**From:** Contact Centre (CRM) <contact@ribblevalley.gov.uk>  
**Sent:** 15 February 2026 21:10  
**To:** Planning  
**Subject:** Planning Application Comments - 3/2025/0988 FS-Case-799265231

**Planning Application Reference No.:** 3/2025/0988

**Address of Development:** Rodhill, 10, Clitheroe Road  
Whalley, Clitheroe. BB7 9AB

PROPOSED GROUND FLOOR PLAN

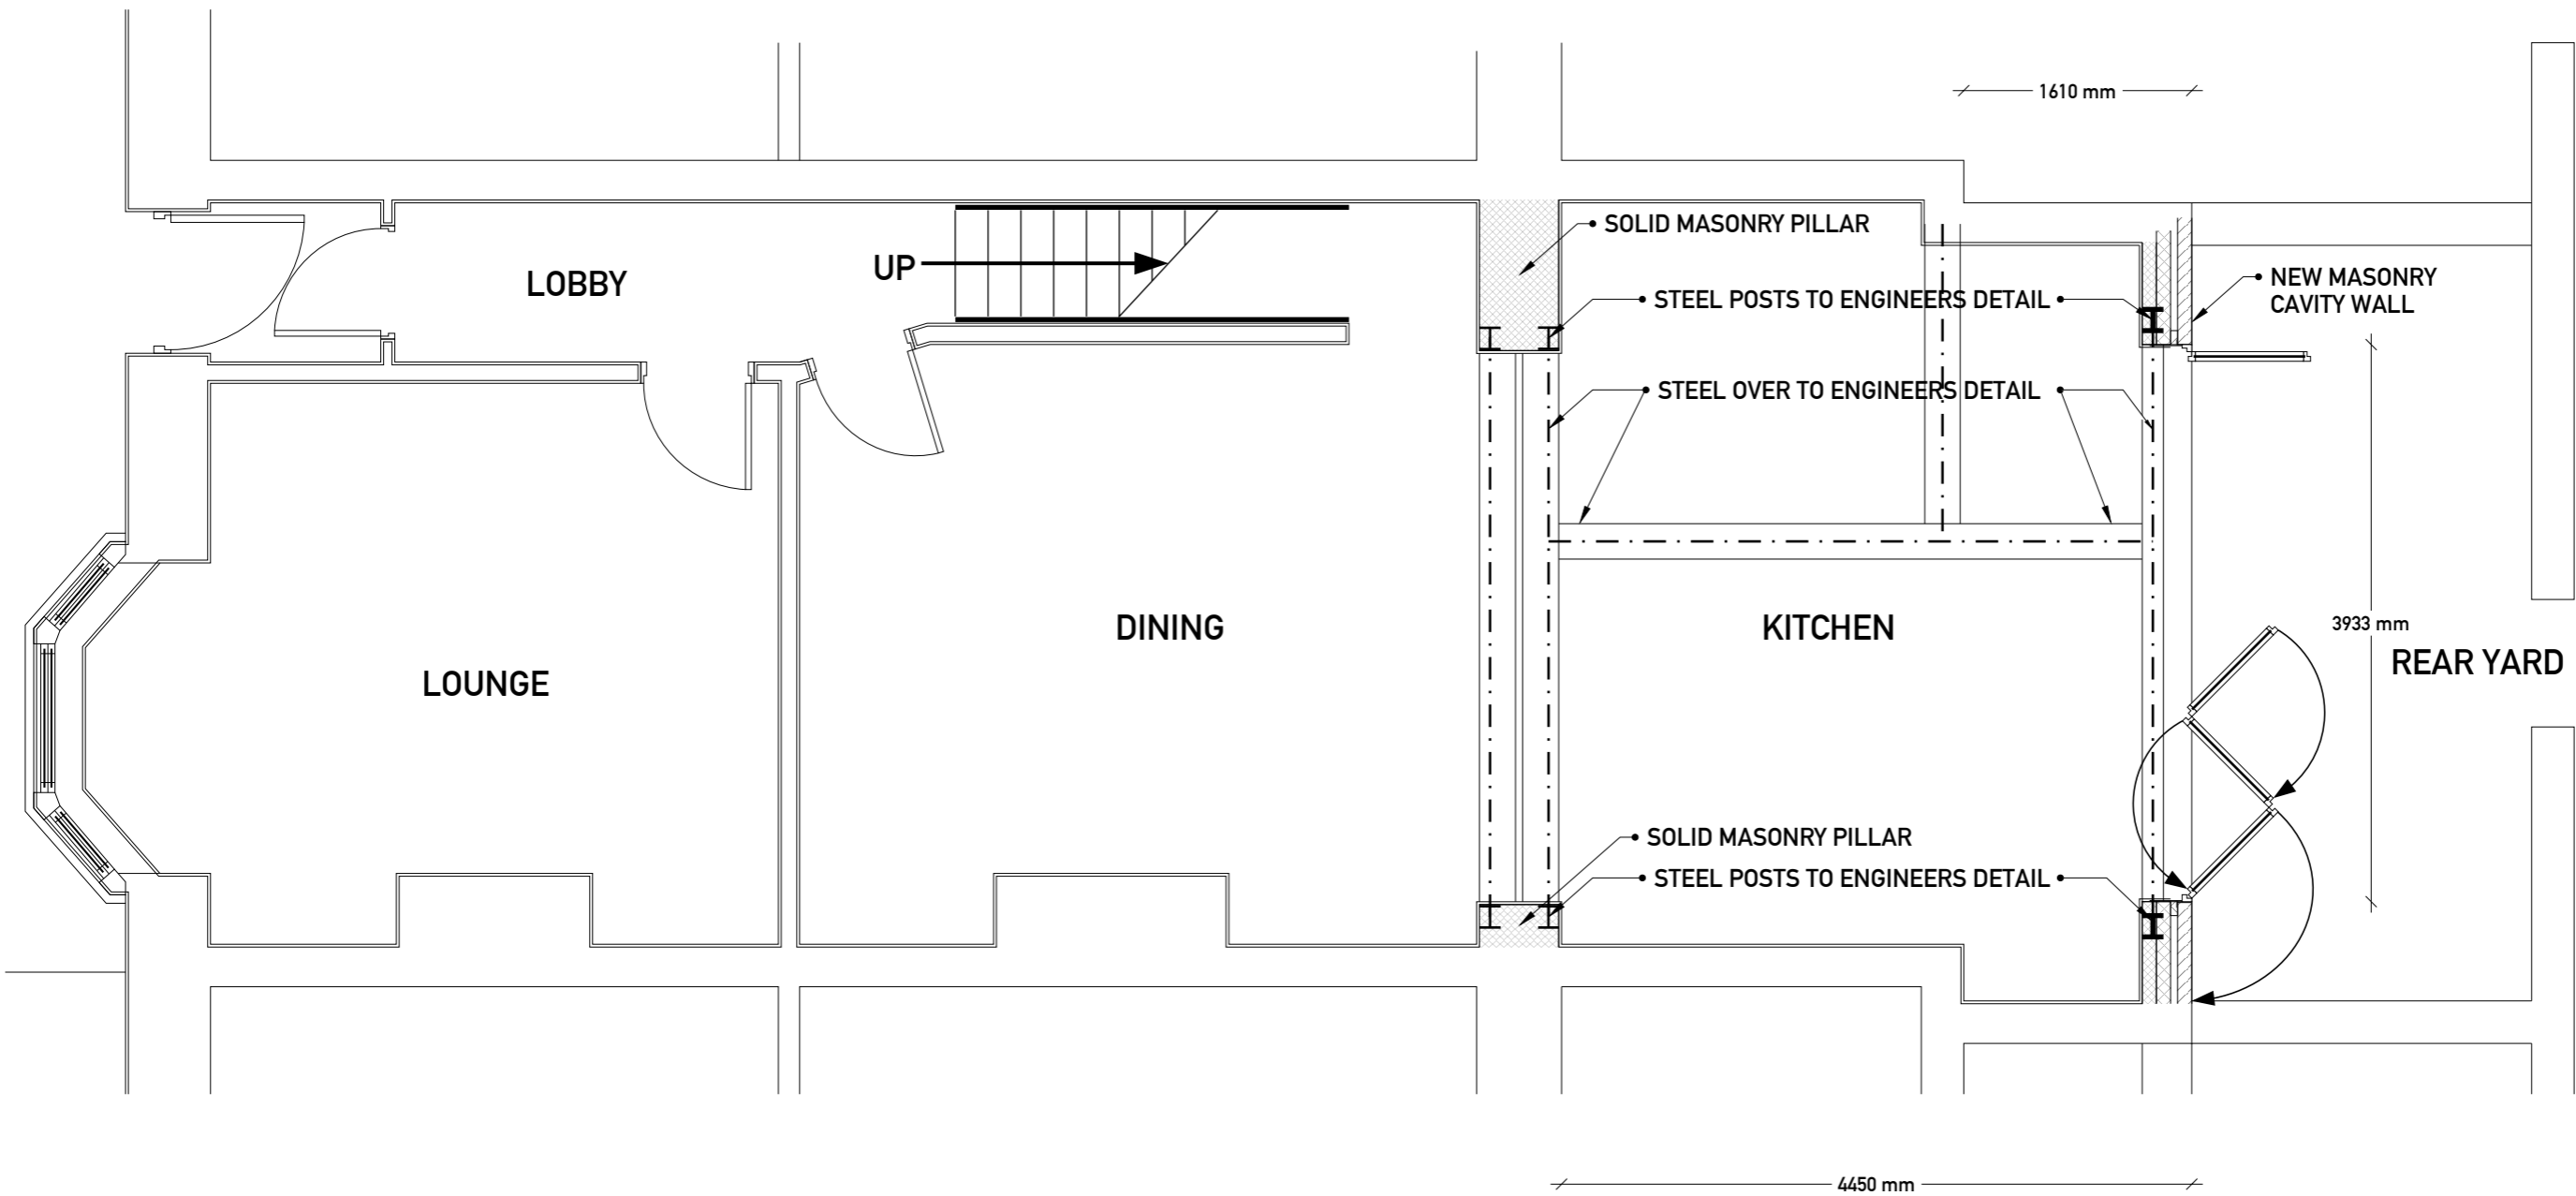
**Comments:** I have already submitted comments on this proposed development. I wish to clarify that in that submission, where I refer to the height of the roof on the proposed extension, I am speaking of metres. (I omitted the definition in my submission.) I understand that the roof to the extension will be 3.07metres high. I regard this as too high because it will block light [REDACTED].
